CITY OF PORTLAND, MAINE
HISTORIC PRESERVATION BOARD

September 6, 2016

Re: 135 Park Street
CBL: 039 A014

This office has approved your application to replace twenty-six windows on the front (24) and southeast end (2) of your property at 135 – 139 Park Street. Approval is based on the plans and specifications included in the application dated June 3, 2016 (revised window specifications supplied later by Rufus Deering Company and by Kent Gordon,) and is subject to the following conditions:

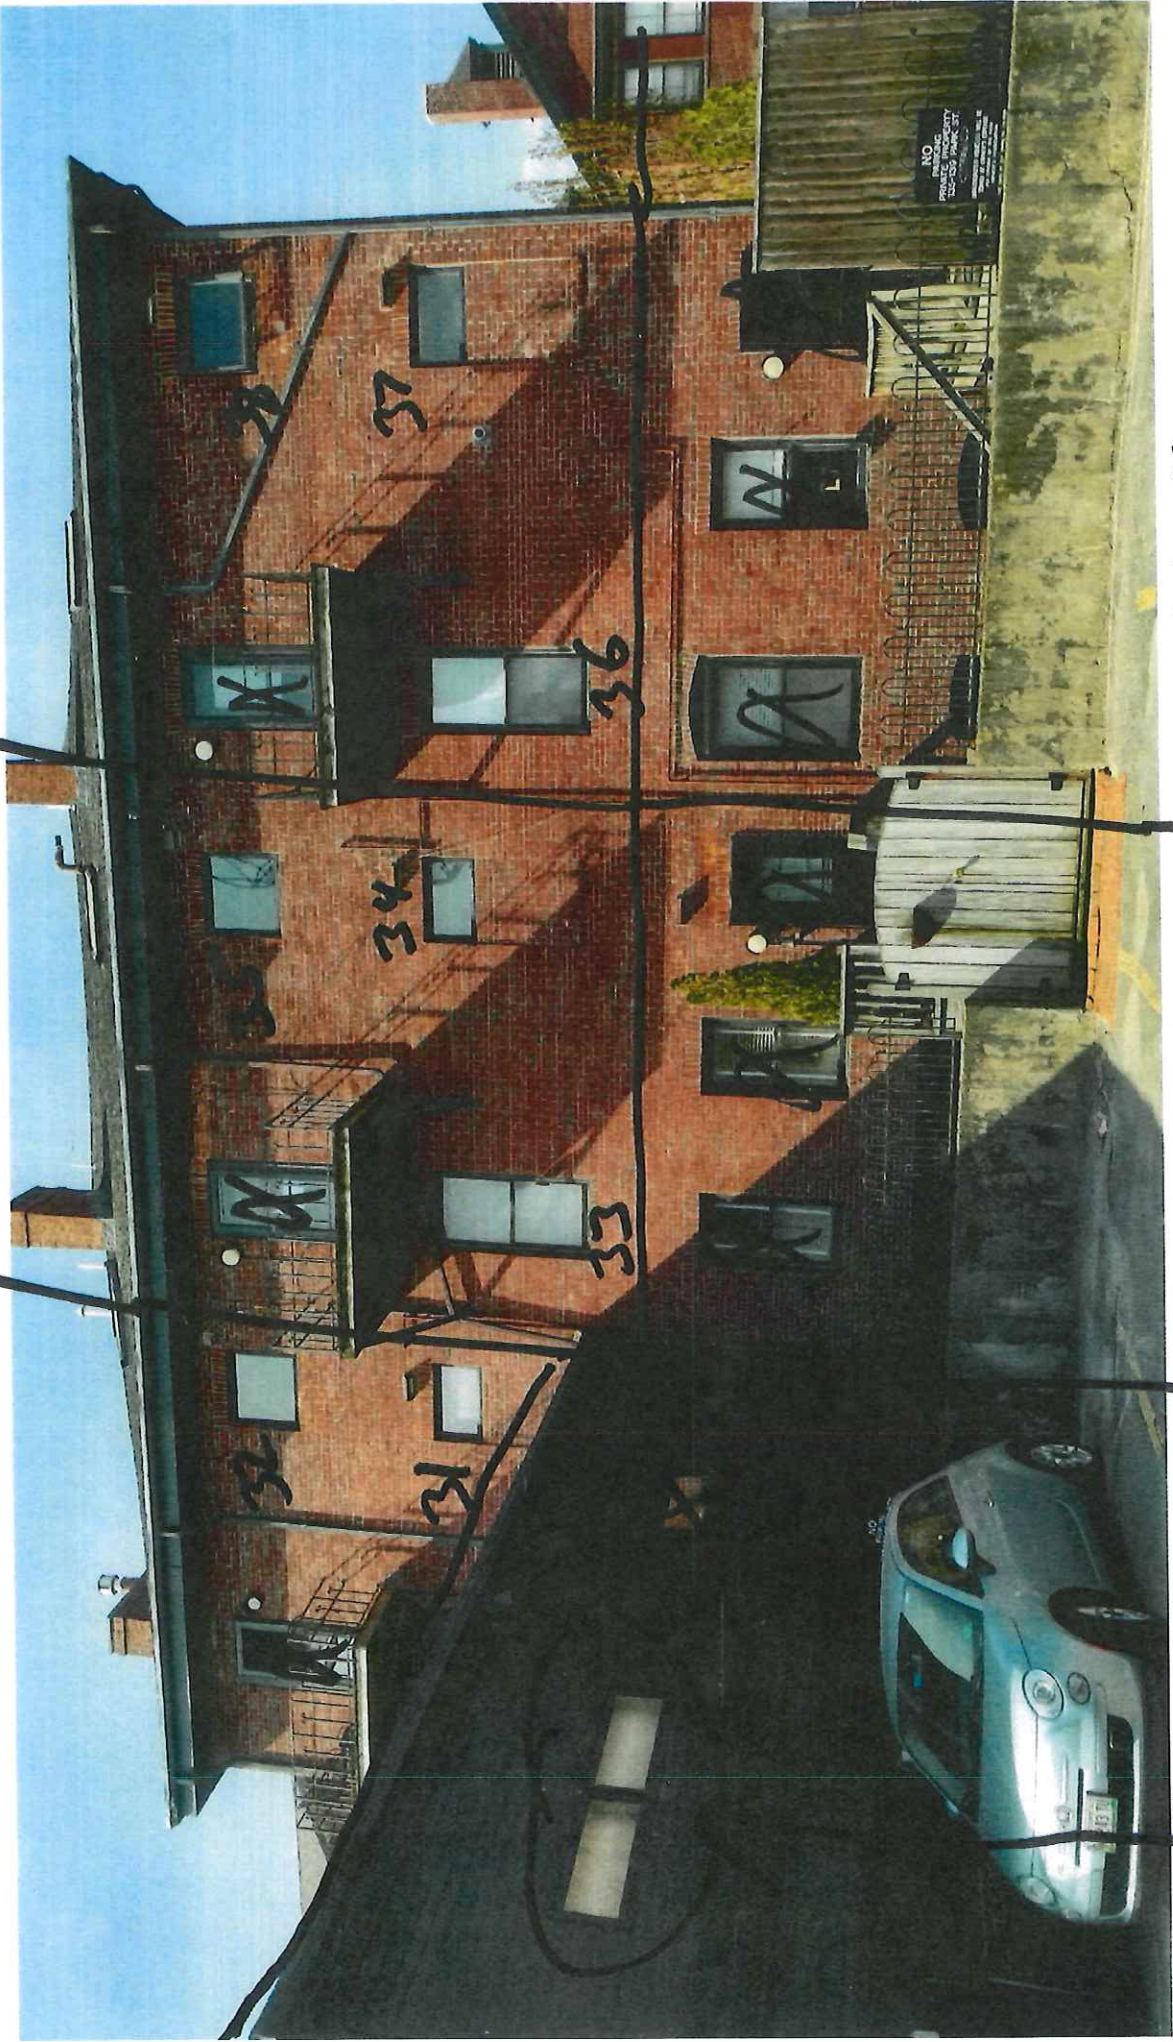
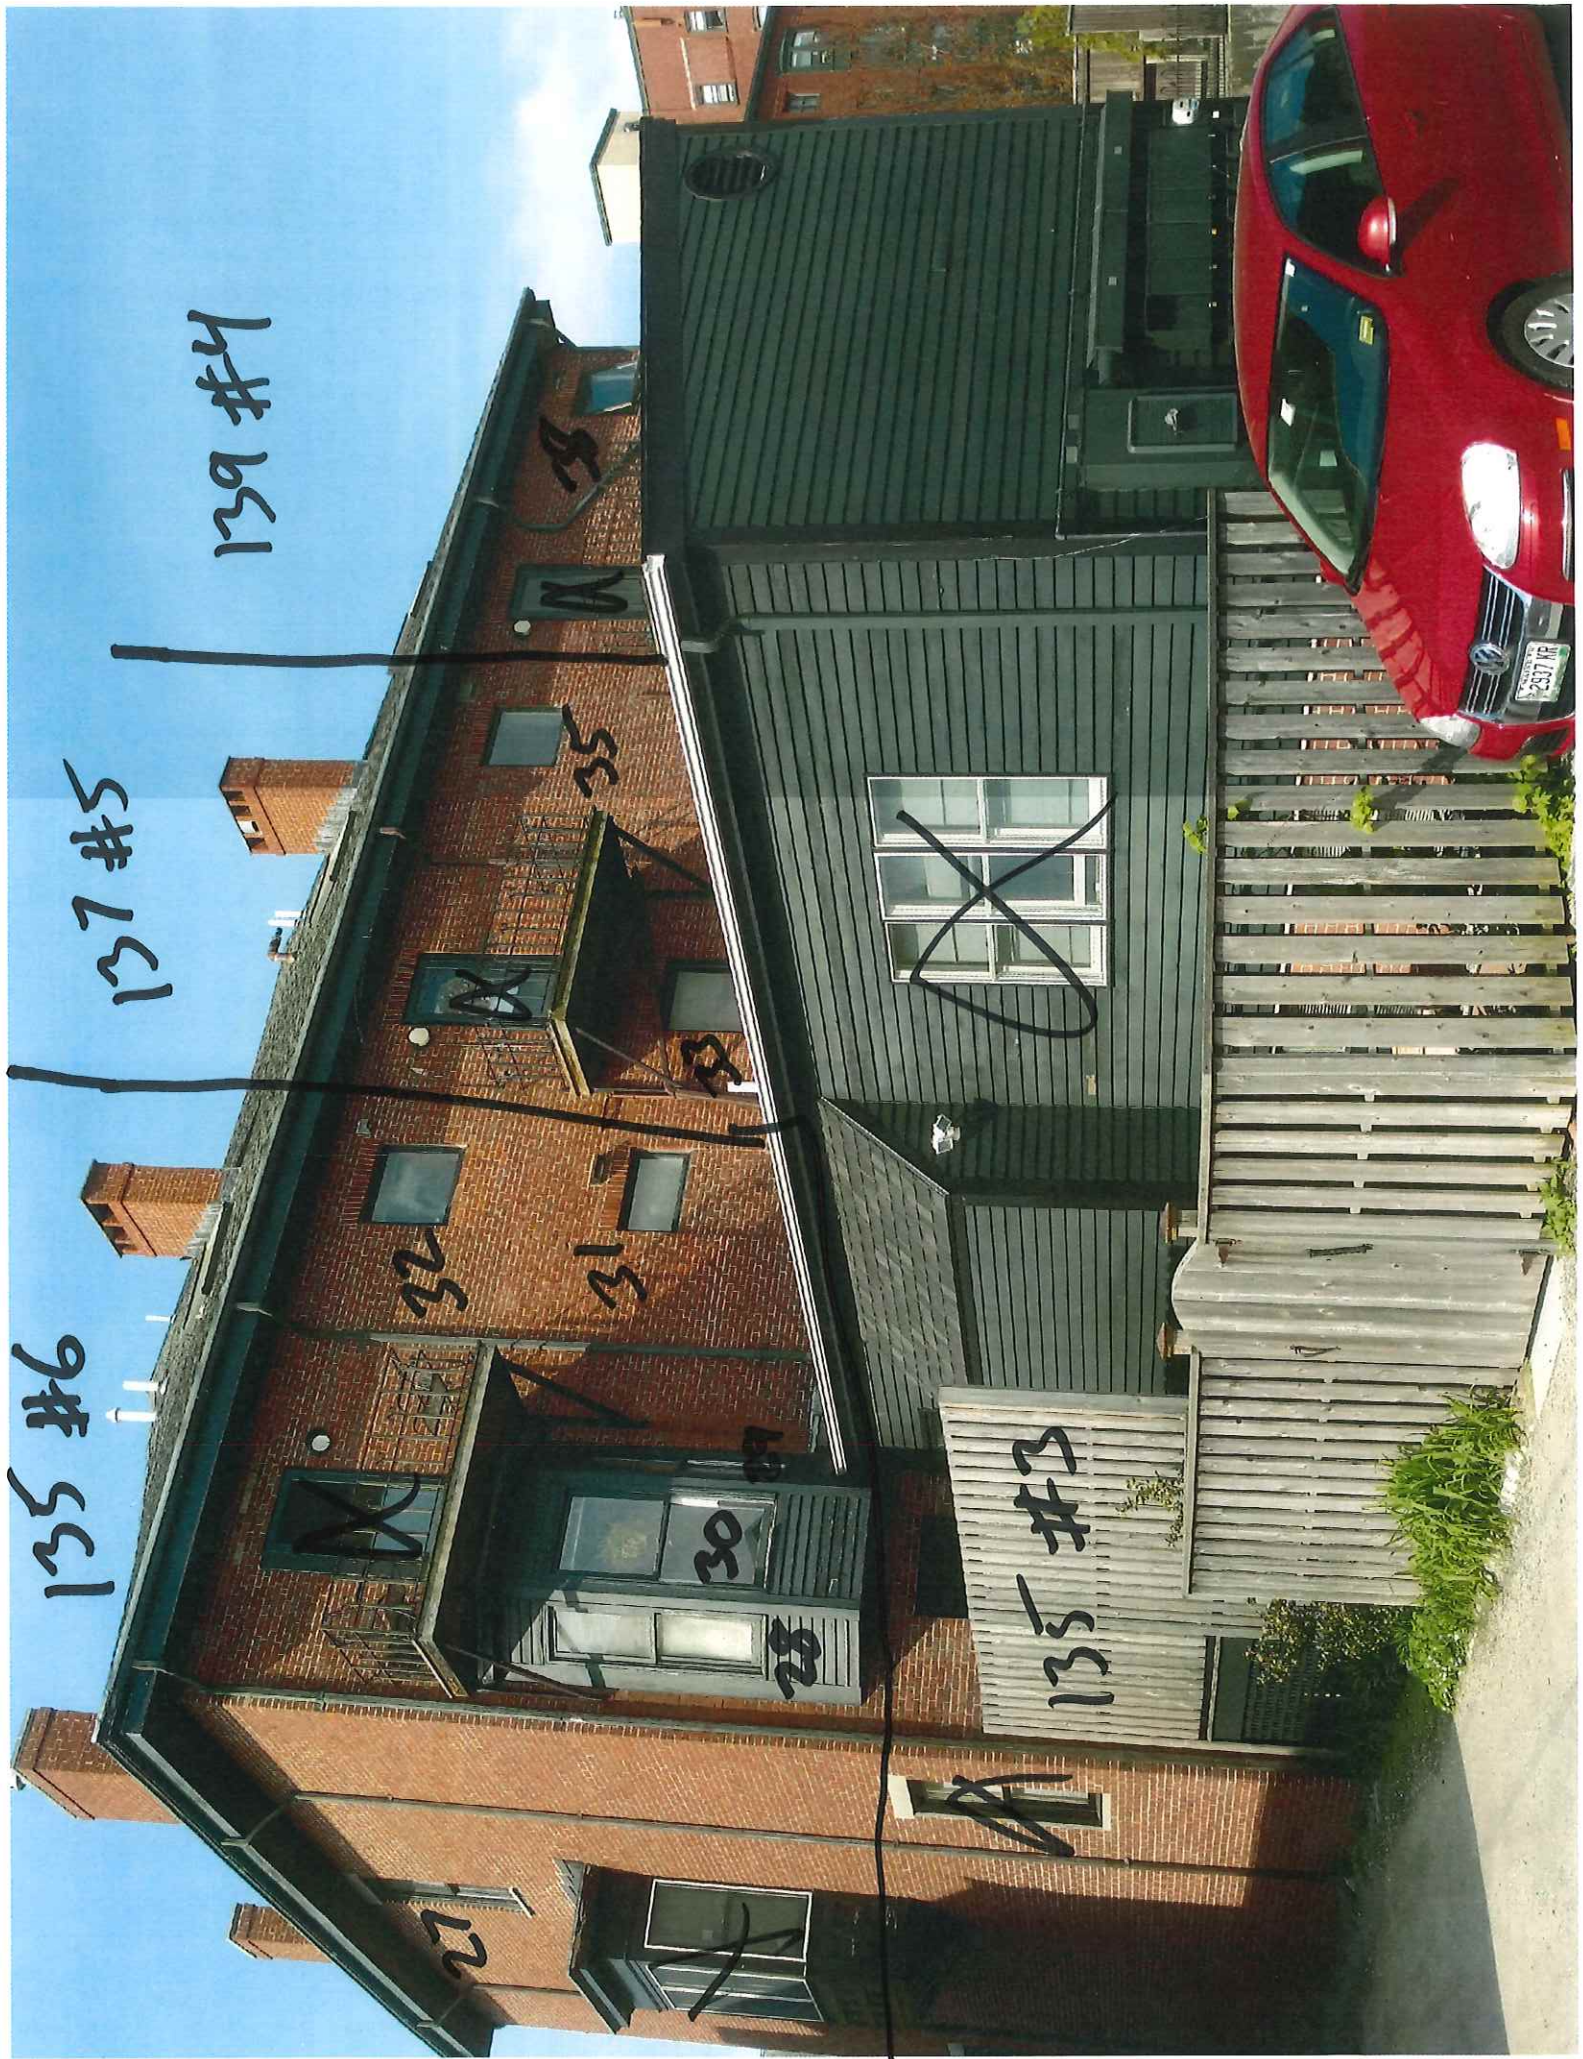
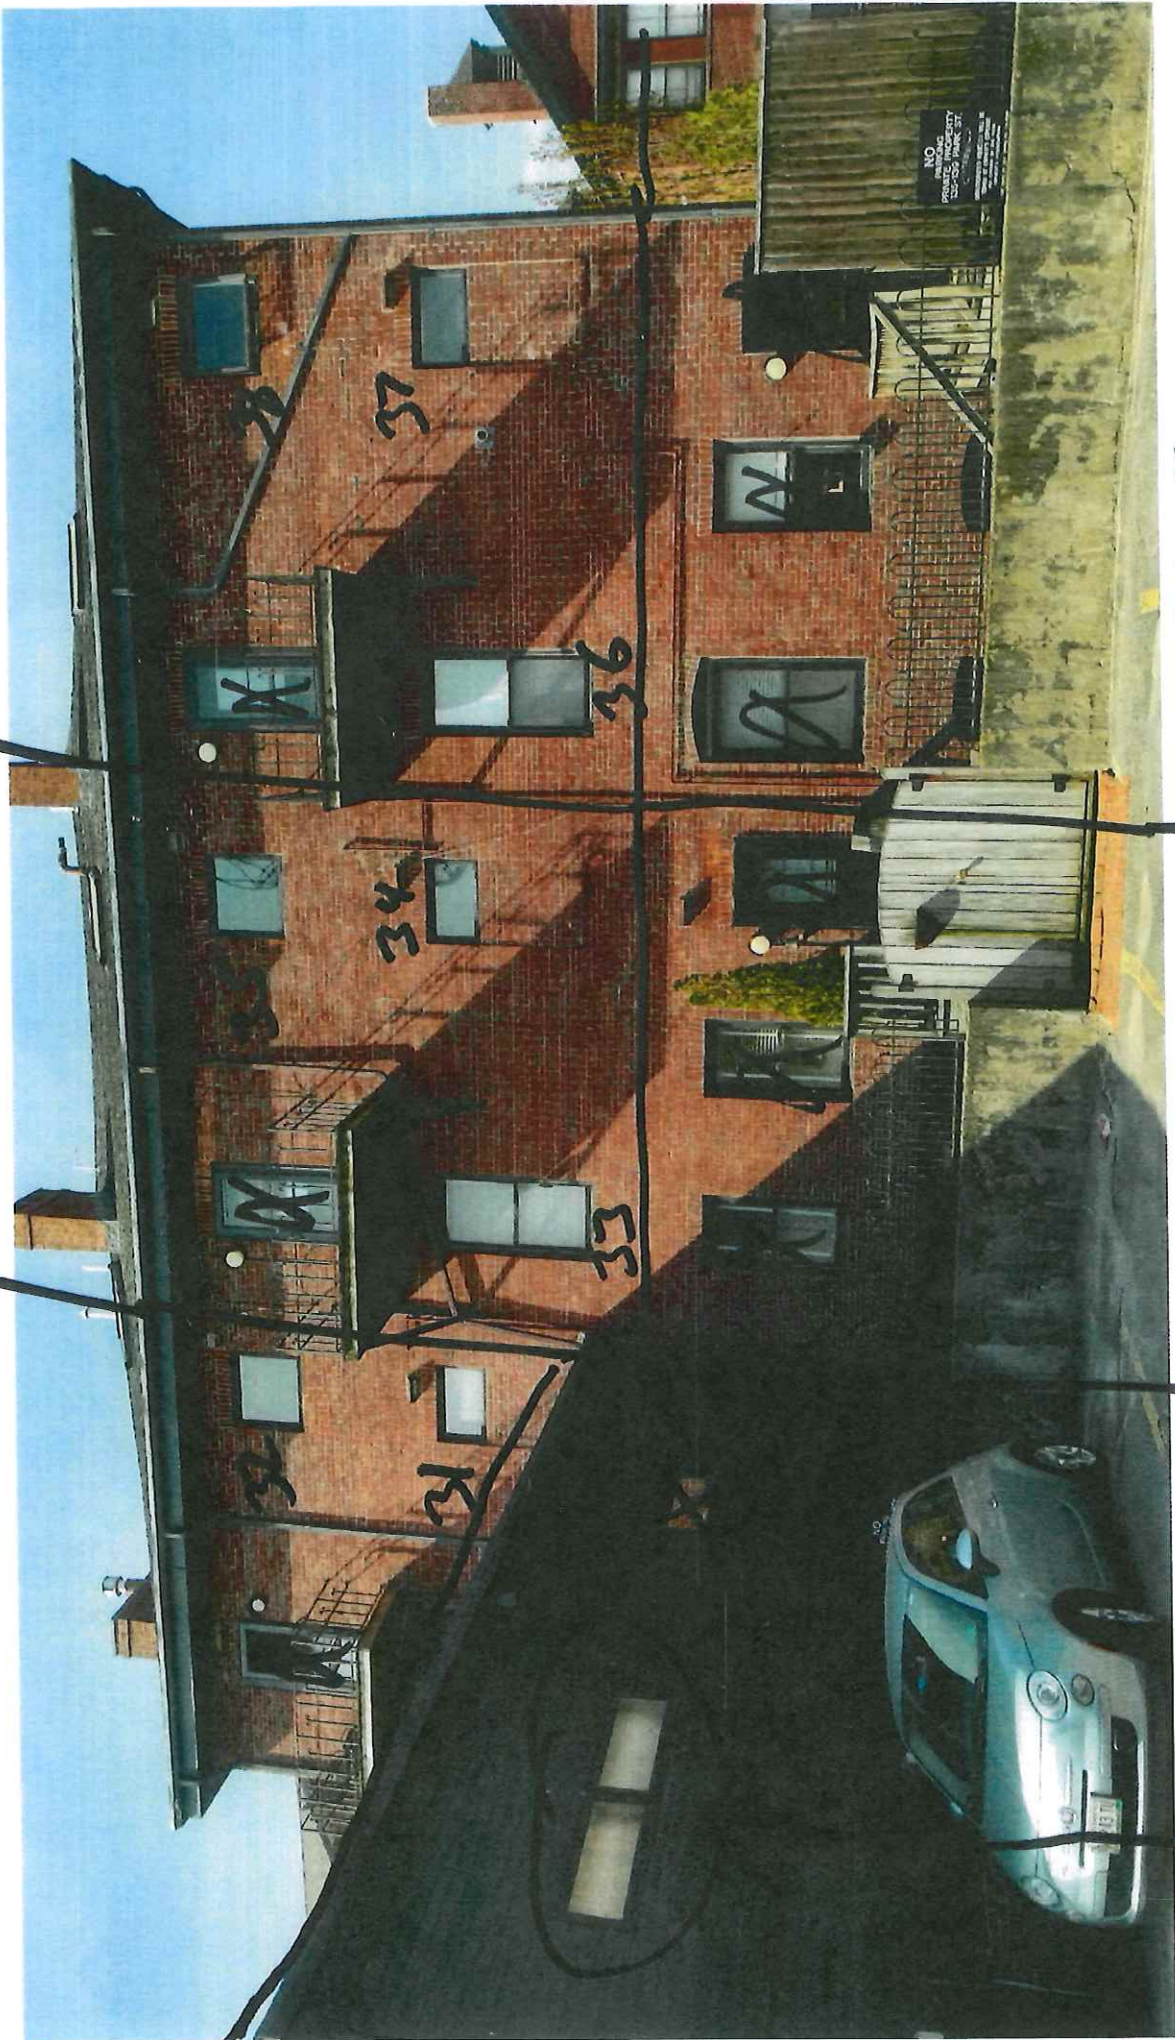
1. HP staff understands the windows are to be Jeld-Wen full-unit (not inserts) clad windows in black, with 5/8" putty glaze profile muntins - simulated divided lights (SDL) on the interior and exterior, with spacer bars. It is understood that the first and second floor windows will be 6/6 and the third floor windows are to be 3/3.
2. If screens are desired they are to be half screens.
3. Visual transmittance of the glass (VTR) is to be .7 or greater, so glass appears clear, untinted, and non-reflective.
4. Painted wood casing and brick mould is to be reproduced on site after window installation, with approximately 2" of flat casing with a staff bead moulding (Brosco B691) on top, at the edge of the masonry opening.
